Recommendation Report for Lawful Development Certificate for a Proposed Use or Development

REF NO: FG/218/21/CLP

LOCATION: 4 Laburnum Close
Ferring
BN12 5EJ

PROPOSAL: Lawful development certificate for proposed sand and cement render of the external walls of the bungalow and then paint the completed render a pale grey or white colour.

DWG NO 994/02 REV. A

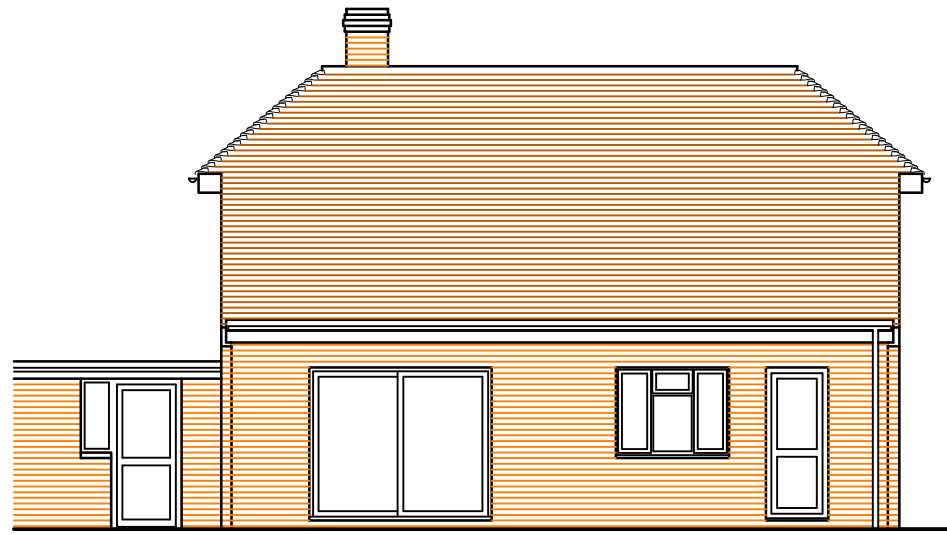
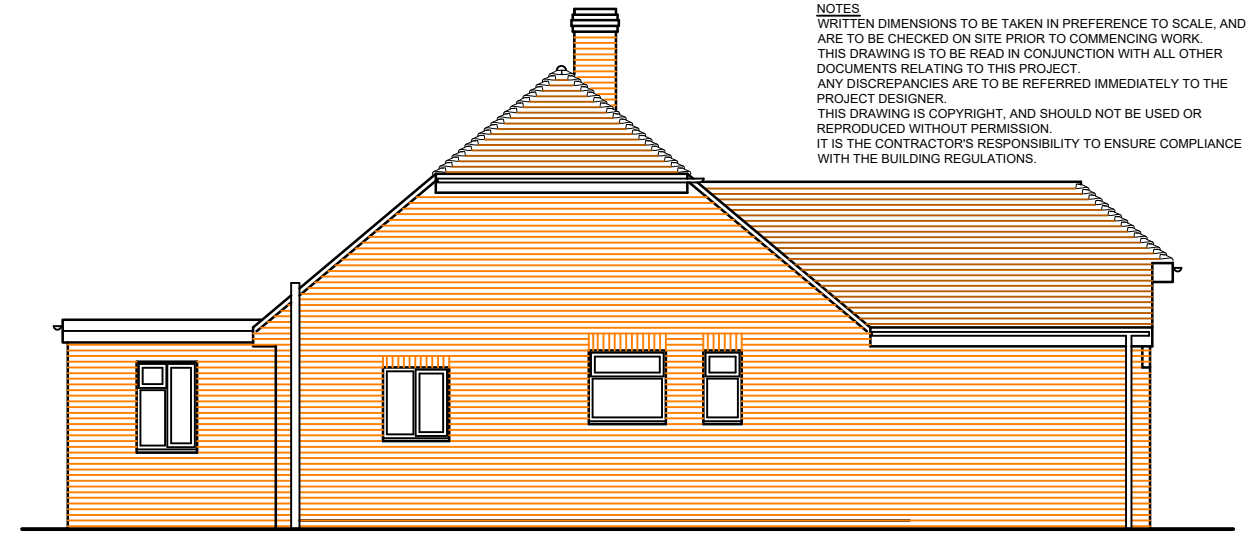
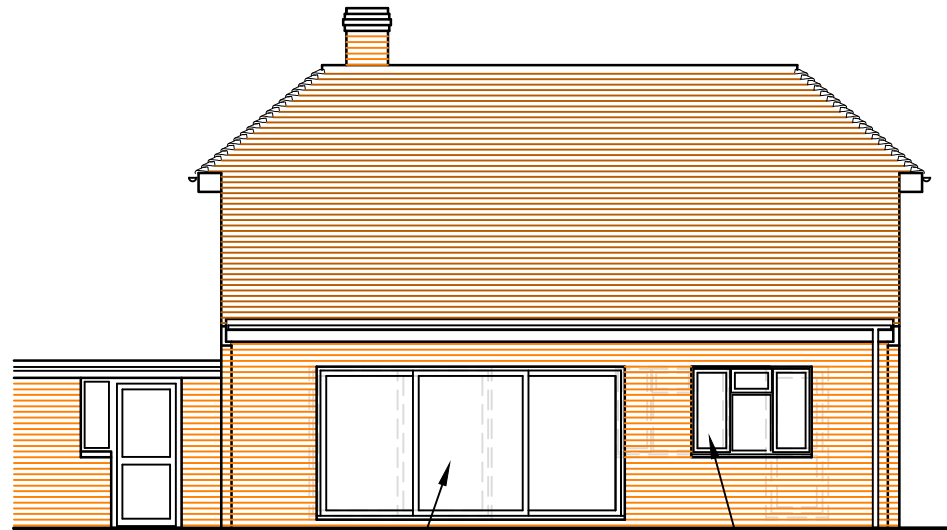
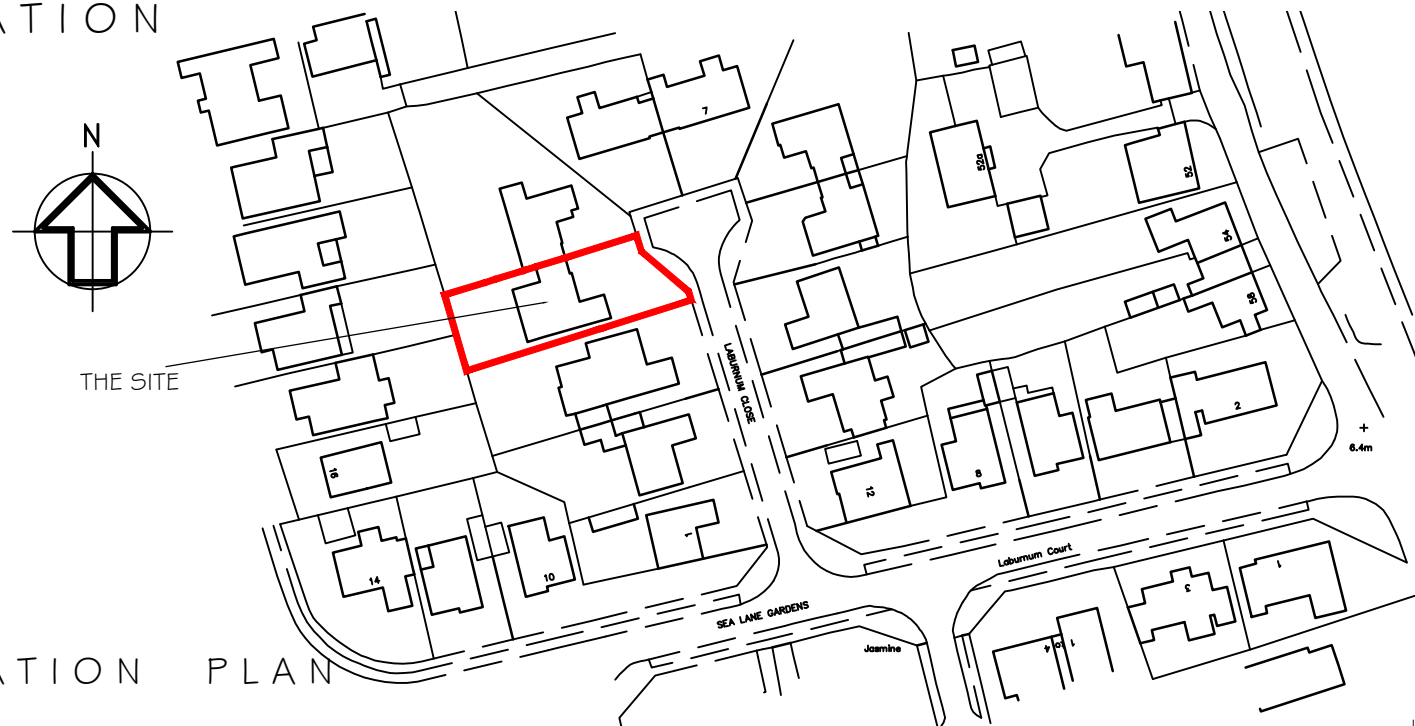
The property known as 4 Laburnum Close is a semi detached property and is not listed or within a conservation area. The proposed extension would not be of materials to match that of the existing.

The proposed alterations do not comply with relevant sections A.3(a), in that the proposed materials are not similar in appearance to those which already exist, and are not considered permitted development and as such does require the submission of an application for full planning permission.
